CITY OF ALBUQUERQUE

December 23, 2019

Re: International District Library
7667 Central Ave NE
Traffic Circulation Layout
Engineer's/Architect's Stamp 12-11-2019 (K19D005)

SHEET NUMBER: 2017.066.1 C100

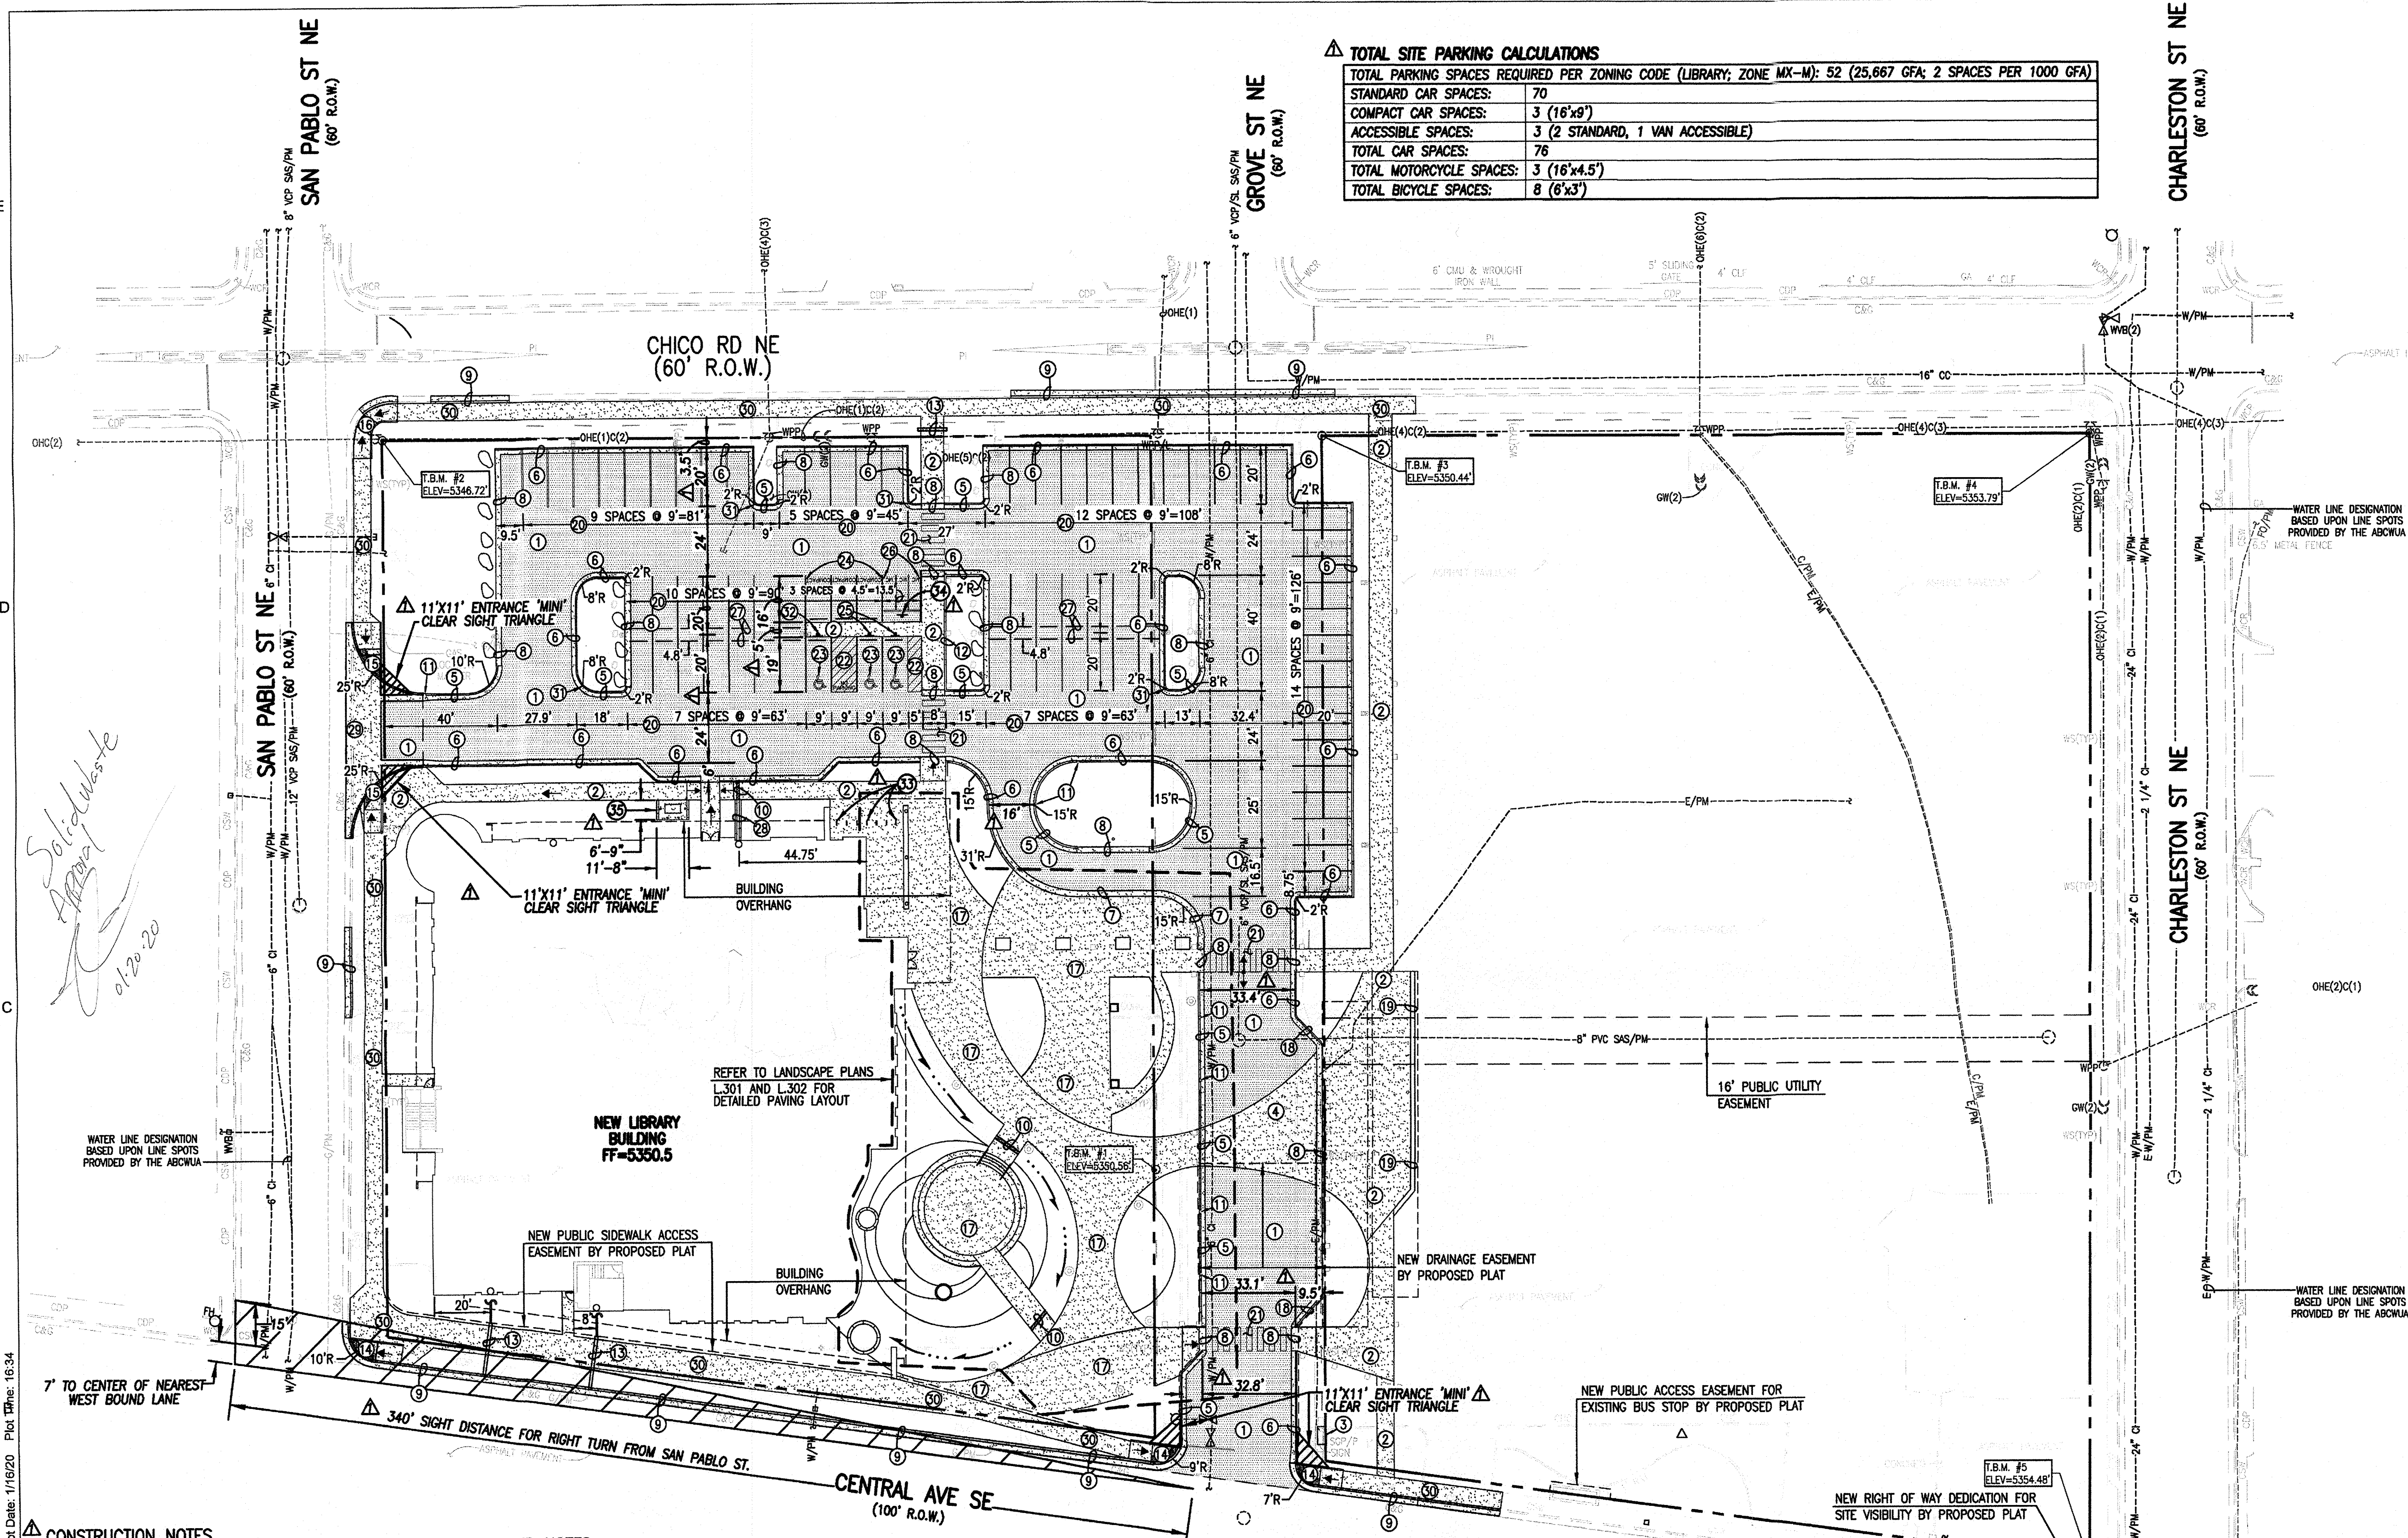
1. A replat is required. If a replat has been done through a DRB process, please attach the approved plat.
2. List the number of parking spaces required by the zoning code as well as the proposed number of parking spaces including bicycle and motorcycle parking.

3. Please list the width and length for compact parking spaces.
4. Motorcycle parking spaces shall be designated by its own conspicuously posted upright sign, either free-standing or wall mounted per the zoning code.

5. All bicycle racks shall be designed according to the following guidelines:
 - a. The rack shall be a minimum 30 inches tall and 18 inches wide.
 - b. The bicycle frame shall be supported horizontally at two or more places. Comb/toaster racks are not allowed.

- c. The rack shall be designed to support the bicycle in an upright position. See the IDO for additional information.
 - d. The rack allows varying bicycle frame sizes and styles to be attached.

- e. The user is not required to lift the bicycle onto the bicycle rack.
 - f. Each bicycle parking space is accessible without moving another bicycle.

6. Bicycle racks shall be sturdy and anchored to a concrete pad.
7. A 1-foot clear zone around the bicycle parking stall shall be provided.
8. Bicycle parking spaces shall be at least 6 feet long and 2 feet wide.

9. Show all drive aisle widths and radii. Some dimensions are not shown.

10. Refuse vehicle maneuvering shall be contained on-site. The refuse vehicle shall not back into the public right of way.; provide a copy of refuse approval.

11. Show the clear sight triangle and add the following note to the plan:
"Landscaping and signage will not interfere with clear sight requirements. Therefore, signs, walls, trees, and shrubbery between 3 and 8 feet tall (as measured from the gutter pan) will not be acceptable in the clear sight triangle.

12. Please add a note on the plan stating "All improvements located in the Right of Way must be included on the work order."
13. Unused curb cuts must be replaced with sidewalk and curb & gutter. A build note must be provided referring to the appropriate City Standard drawing.

14. Add a note stating "All broken or cracked sidewalk must be replaced with sidewalk and curb & gutter." A build note must be provided referring to the appropriate City Standard drawing.
